Your Ref :
Our Ref : AL/44/14/NMA

Application for Non-Material amendment following a grant of planning permission AL/89/10 - relating to minor external changes to fenestration within approved elevations to plot 4 only. Land rear of Swan Court, Pine Close, Westergate, Aldingbourne

The above changes can be accepted as a non material amendment to planning approval AL/89/10. The submitted Floor Drg No 1643/08b and Elevations Drg No 1643/09 now become the approved plans for Plot 4.

Plot 4
A3 @ 1:100

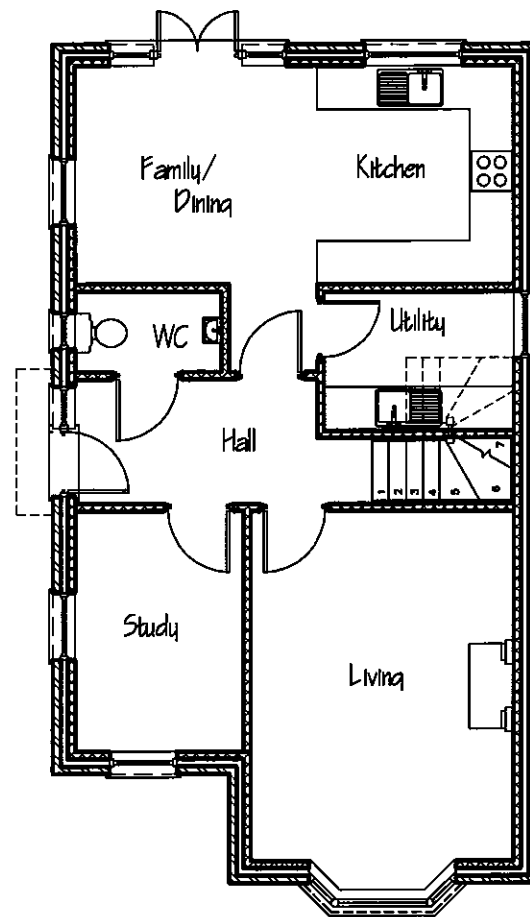
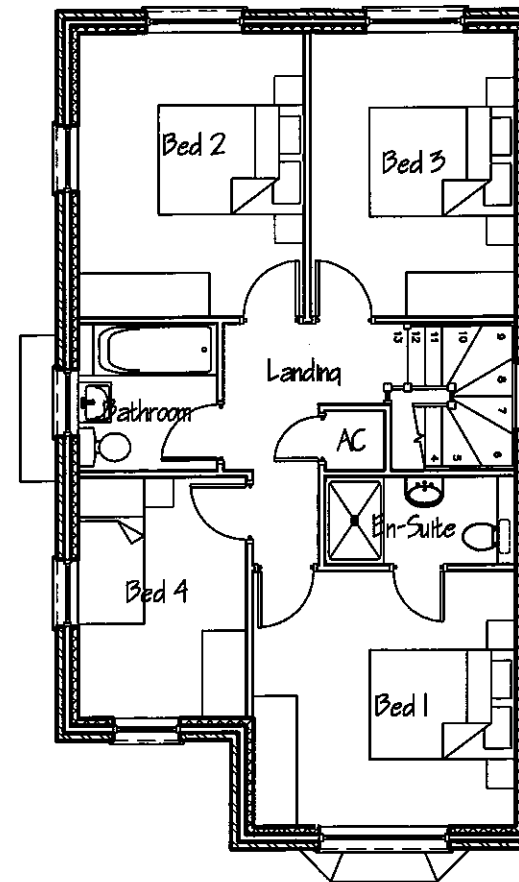
The changes to the external fenestration of Plot 4 to include:
Introduction of two false windows and obscure glazed window on the side elevation.
Obscure glazed windows on the side elevation serving the landing and en-suite and the removal of the utility room window at ground floor level.
Change in roof tile from Dreadnought tiles - sand faced brown heather to plain clay roof tiles.
Red multi facing brickwork.
Terracotta brick string course, sills and arches.
